CITY OF MERCER ISLAND

RE: Review Comments for File No. CAO17-010 – Hou Critical Areas Determination
4825 E Mercer Way, Mercer Island, WA 98040; King County Tax Parcel # 216200-0070

GRADING AND DRAINAGE PLAN - T.E.S.C. PLAN

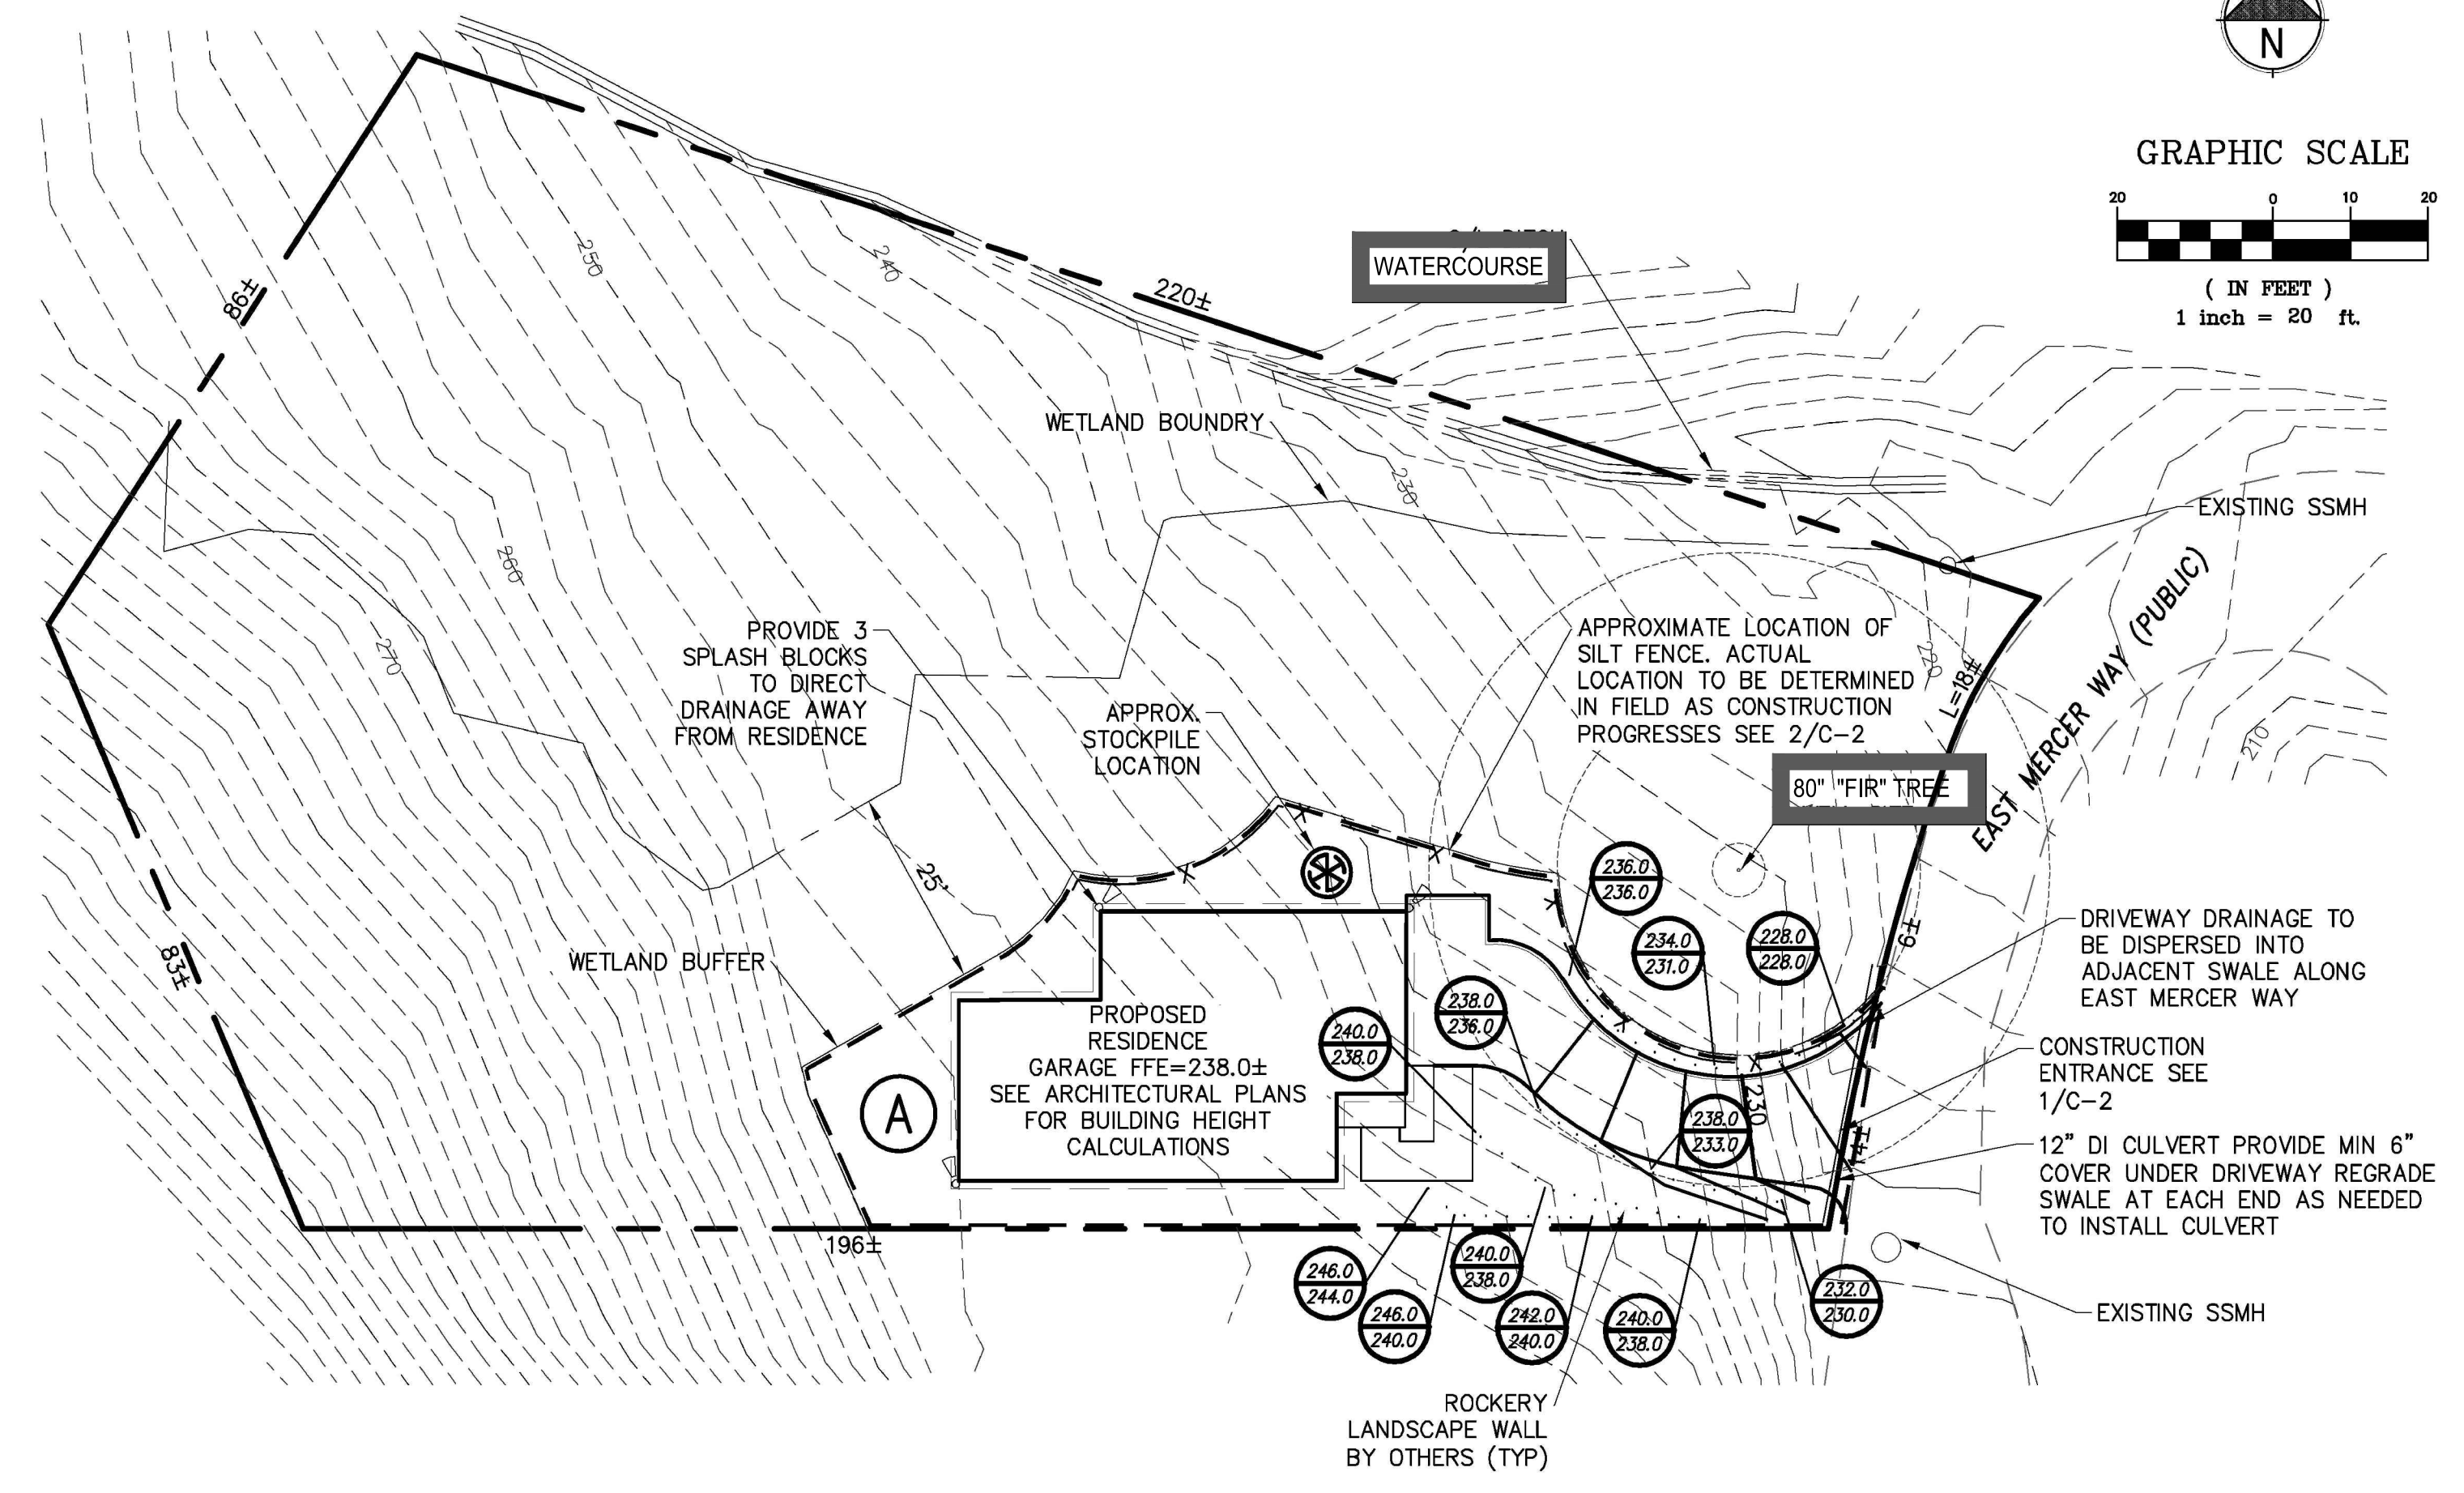
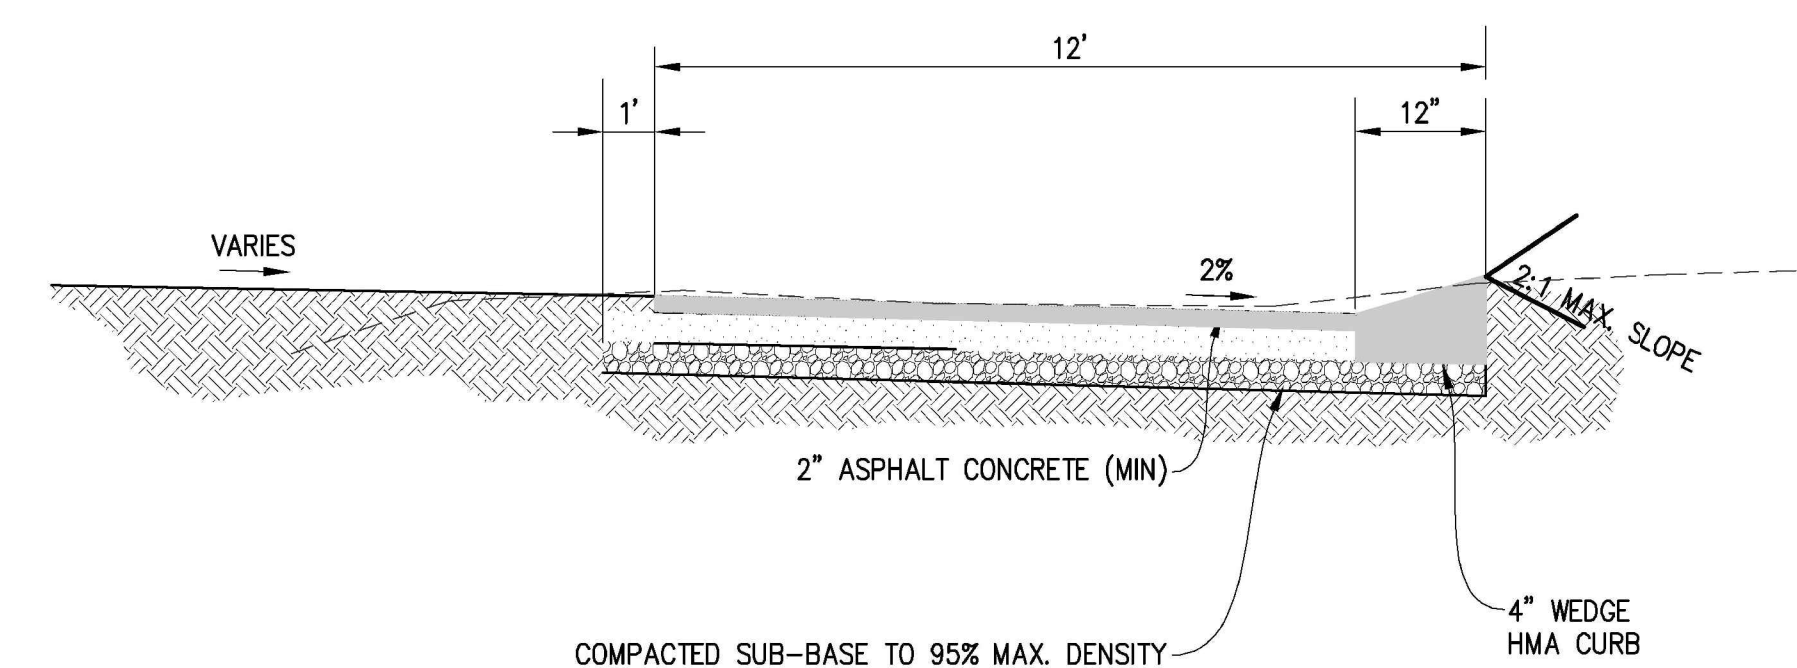
1. Thank you for performing the root evaluation. It has provided staff with necessary information to move this project forward. As recommended in the arborist report, please provide a driveway design prepared by an engineer. This design is needed by staff to understand how the tree, and its roots, may be impacted by construction of the proposed driveway.
